HERTFORDSHIRE ECOLOGY

Proposal: Erection of three storey business and social building, associated drainage, landscaping and ancillary works

Address, De Havilland Campus University Of Hertfordshire Mosquito Way Hatfield

Application No: 6/2018/2150/MAJ

TREE REMOVALS PLAN

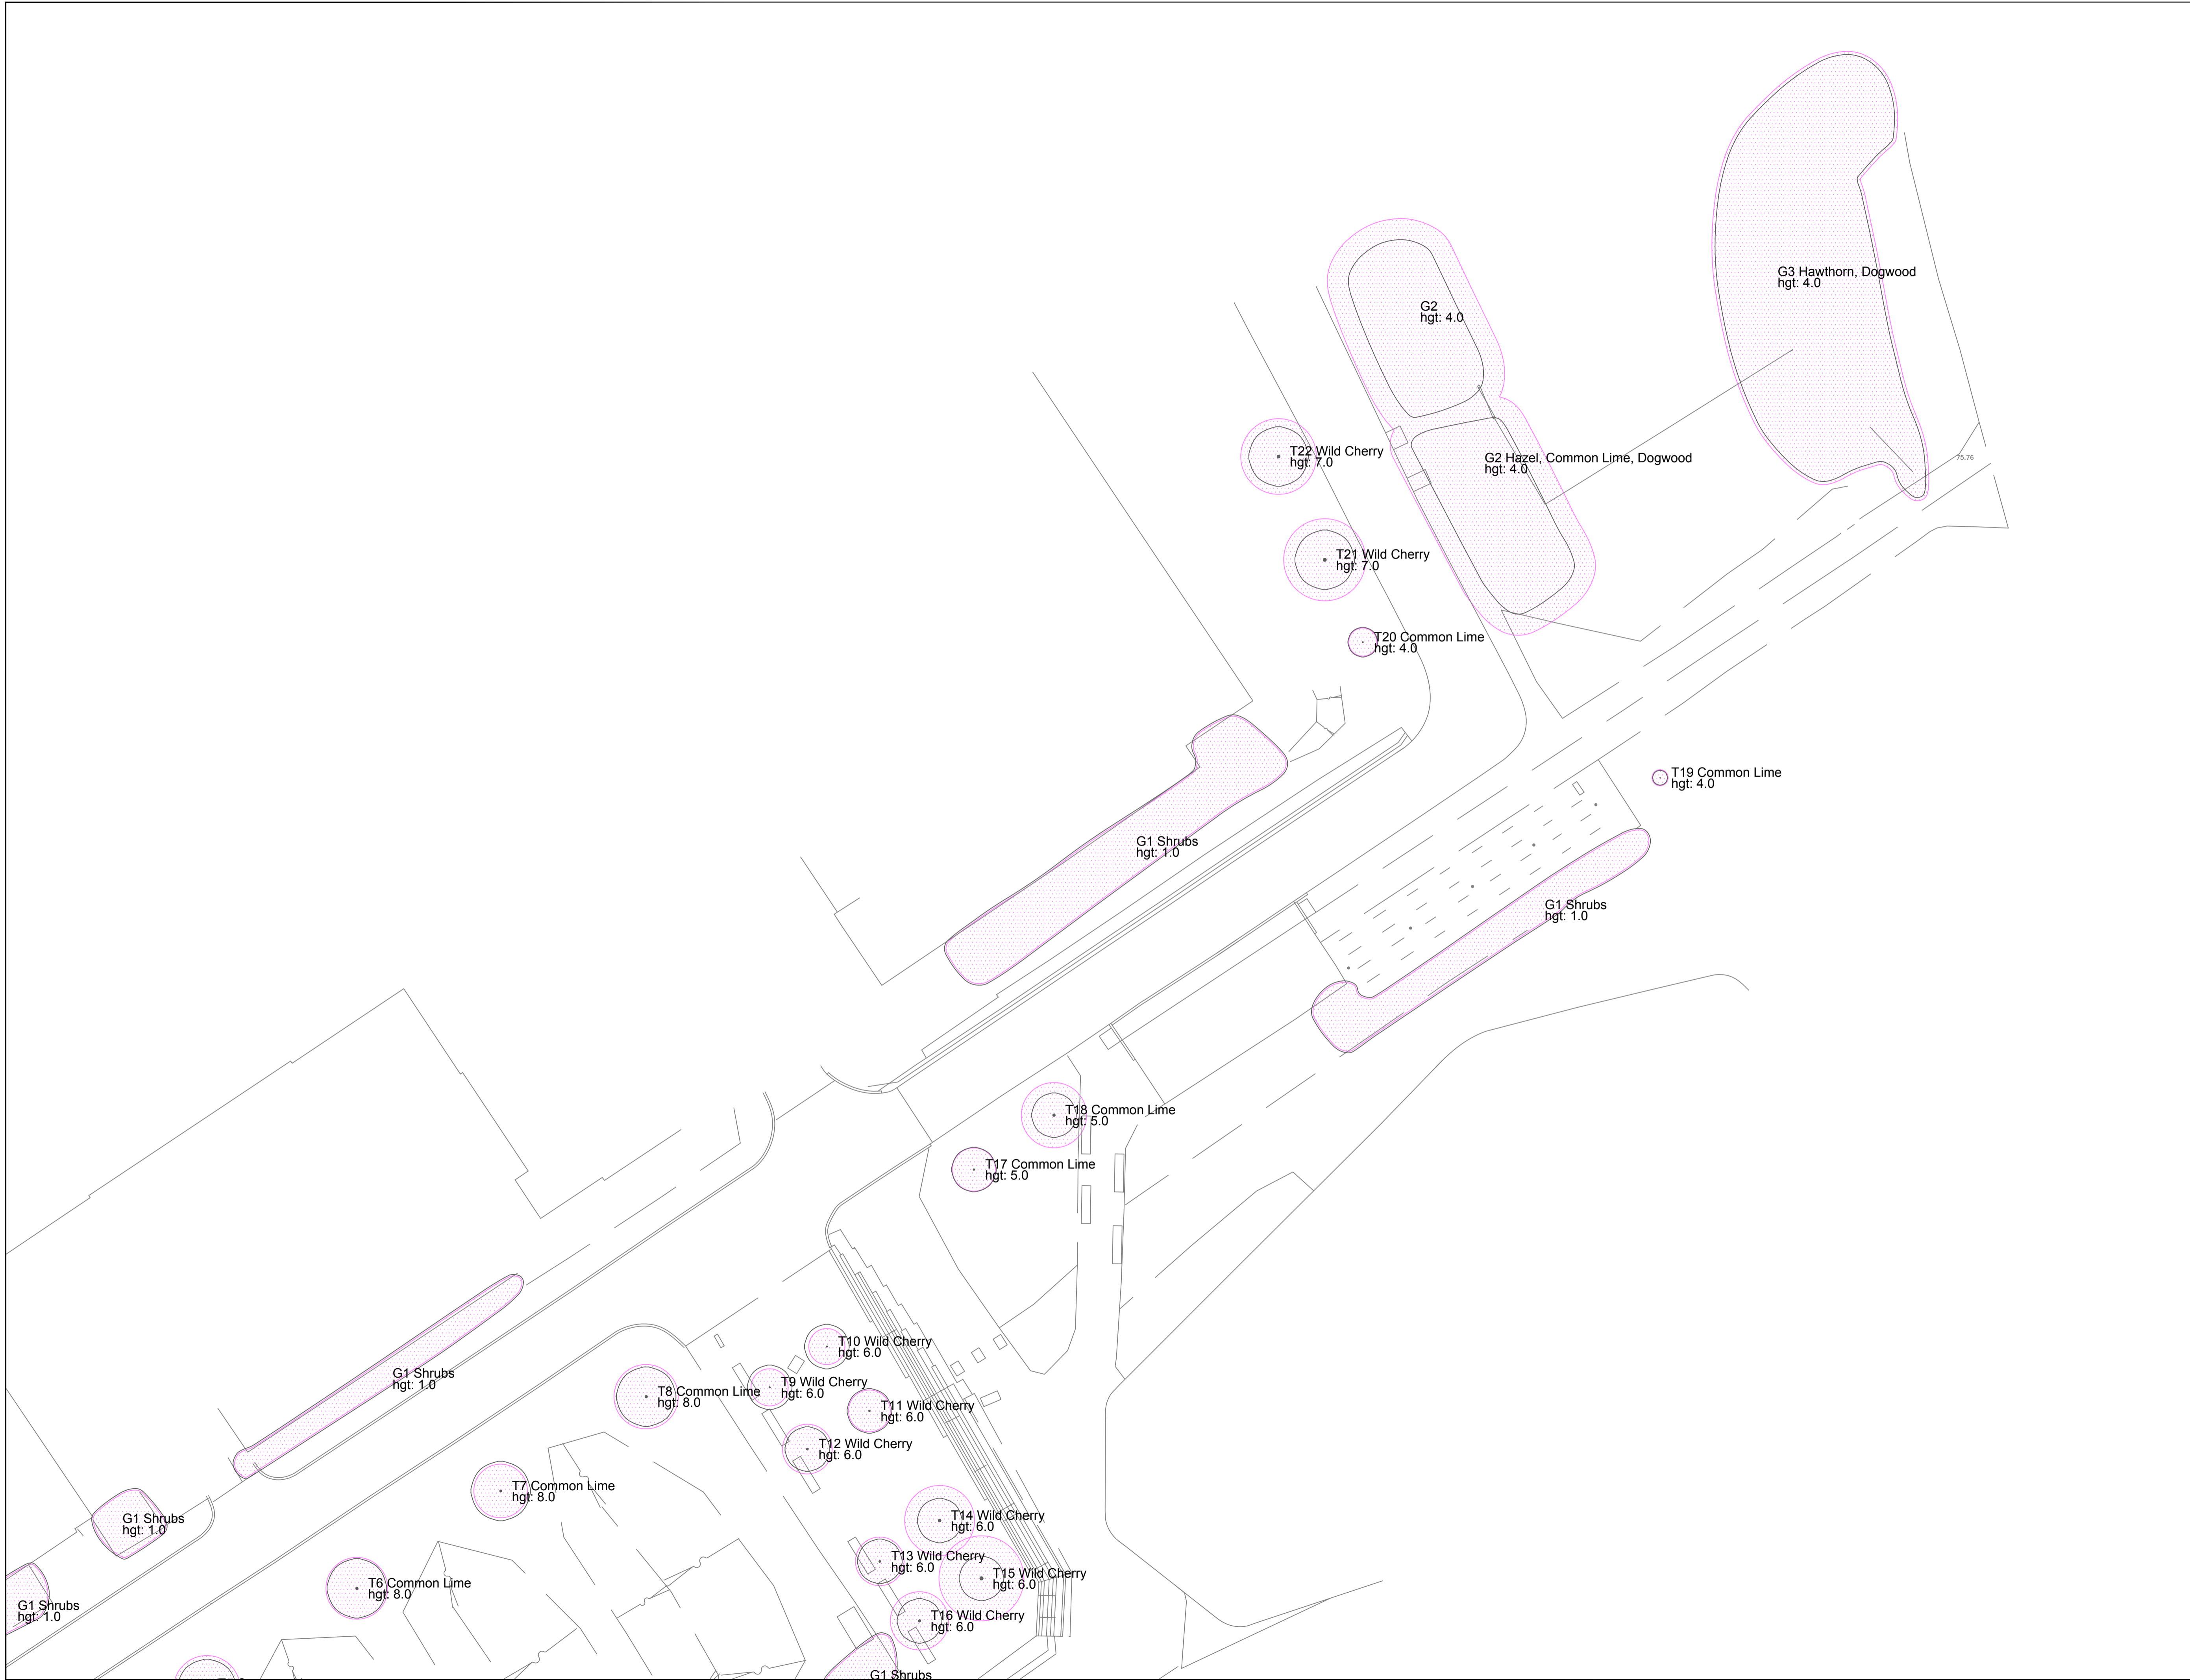
The erection of the three storey building involves the removal of 7 common lime trees and an area of amenity grassland. This recently landscaped area is of little intrinsic value but the proposals will result in a locally significant loss of open space and habitat. Whilst of low value, this loss cannot be compensated for on-site – it is being replaced by 6 pine trees. Proposed evergreen hedge planting to the north facade of the building mirrors the formal line of planting on the other side of the road. However it adds limited ecological value to proposed planting of the site.

Clearly there will be a loss of open space, amenity planting and associated biodiversity as a result of the development. Given there is little opportunity on-site to sufficiently compensate for this loss, I suggest a sum of £2.500 is provided as Biodiversity Offsetting to supplement local ecological resources elsewhere, to offset the impact of this development. This would need to be secured through a formal S106 Agreement and a suitable project identified to ensure no net ecological loss / enhancement is achieved, consistent with the aims of NPPF.
